**Planning Application No: 3/2026/0013**

**Proposal: Proposed change of use from dwelling house (Class C3) to residential children's home (Class C2) for up to 2 children aged 4-18.**

**Location: 2A Monks Drive Longridge PR3 3FR**

BLOCK PLAN  
PARKING OPTION 2

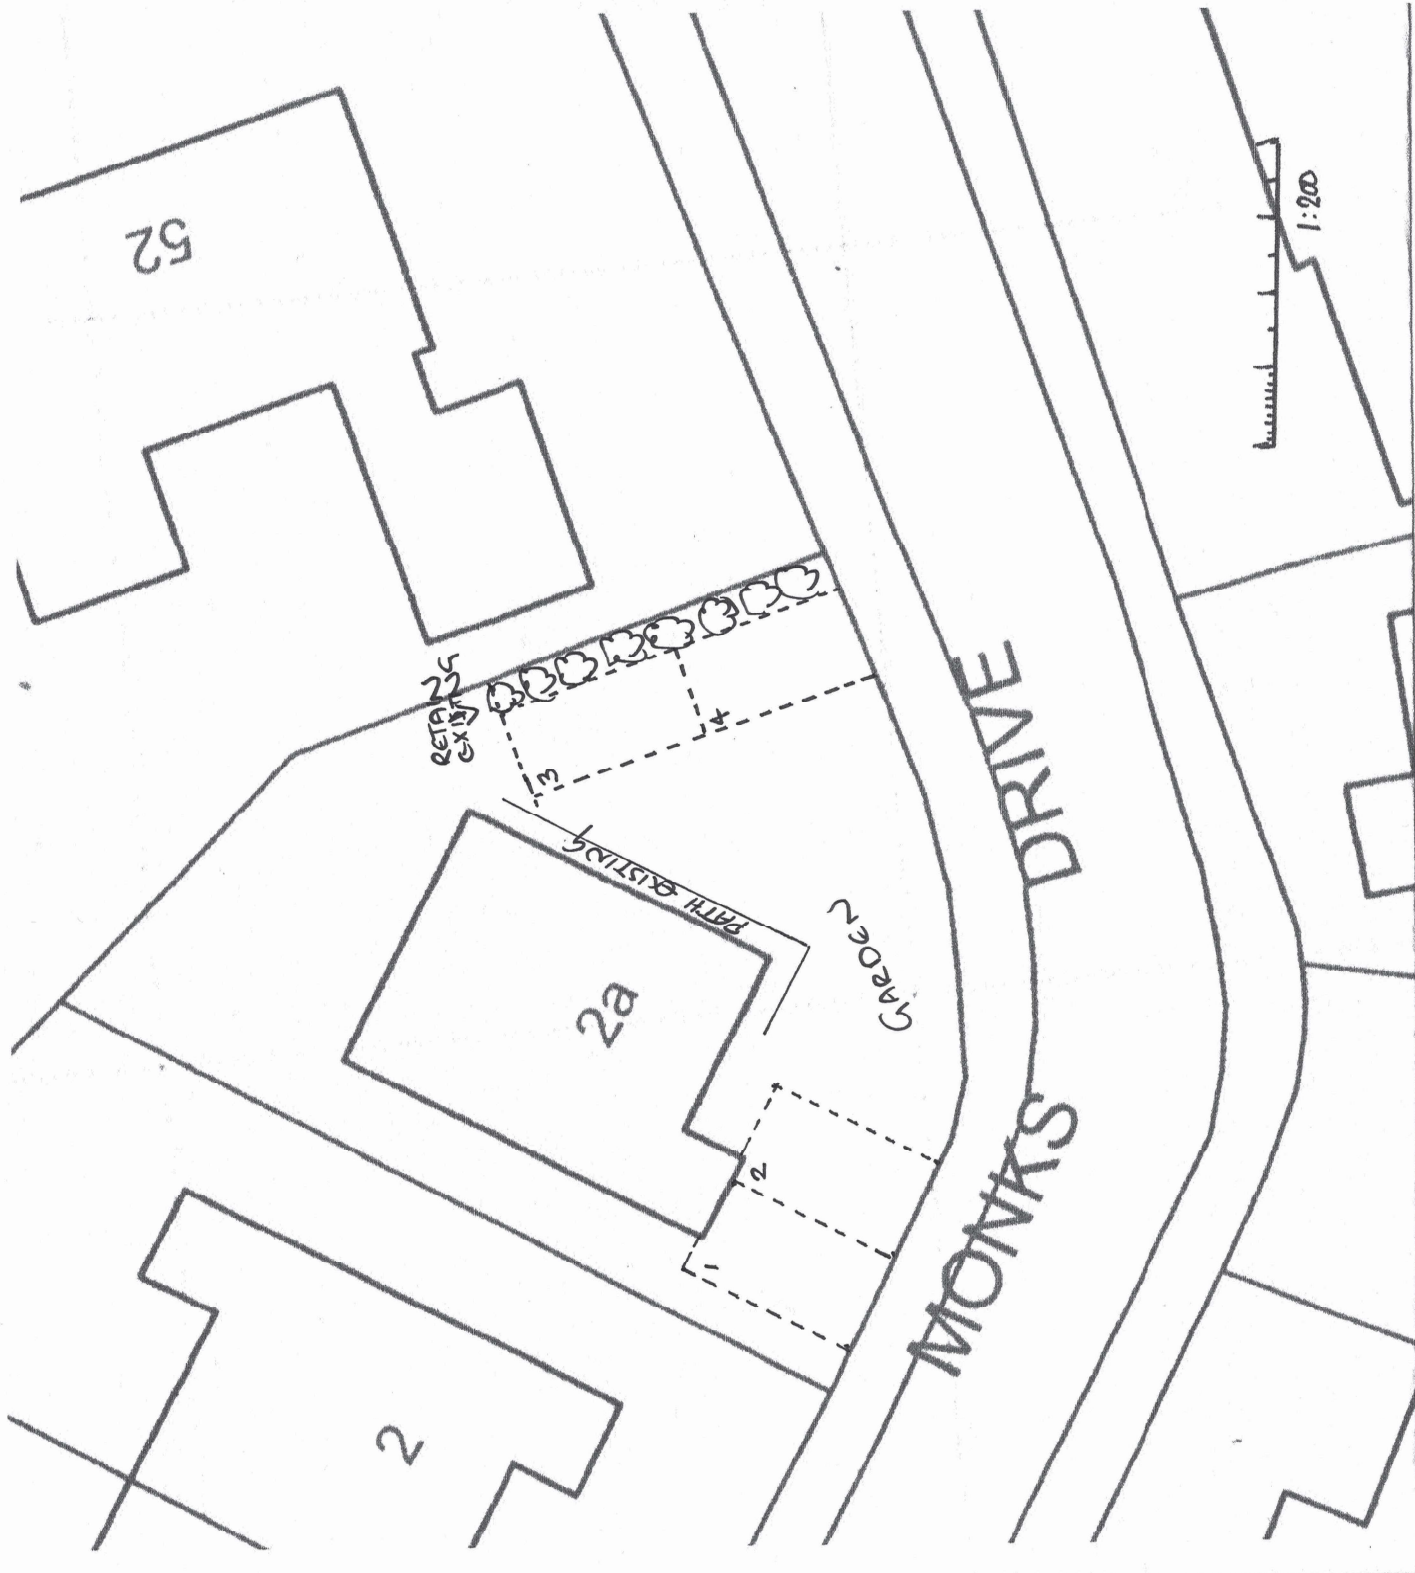
With ref. D & A Statement, it is noted that space for 2 bicycles shall be provided and maintained thereafter for that purpose. Reason: To support sustainable travel.  
Supporting document submitted, Parking Option 2 is preferred, as side by side 4 parking spaces are more accessible making them usable parking spaces. The access will need to be widened to the full width of the drive.

- The development hereby permitted shall not be occupied or brought into use until the Proposed Site Plan submitted showing 4 car parking have been provided in full and are available for use. The car parking shall thereafter be kept available for the parking and manoeuvring of vehicles at all times. Reason: To ensure the provision of adequate car parking on site and in the interests of highway safety.
- The parking areas must be constructed of a bound porous material and created before first occupation up until the lifetime of the dwelling existing in its proposed state. Reason: To ensure that satisfactory parking is provided before the dwelling hereby permitted becomes operative.
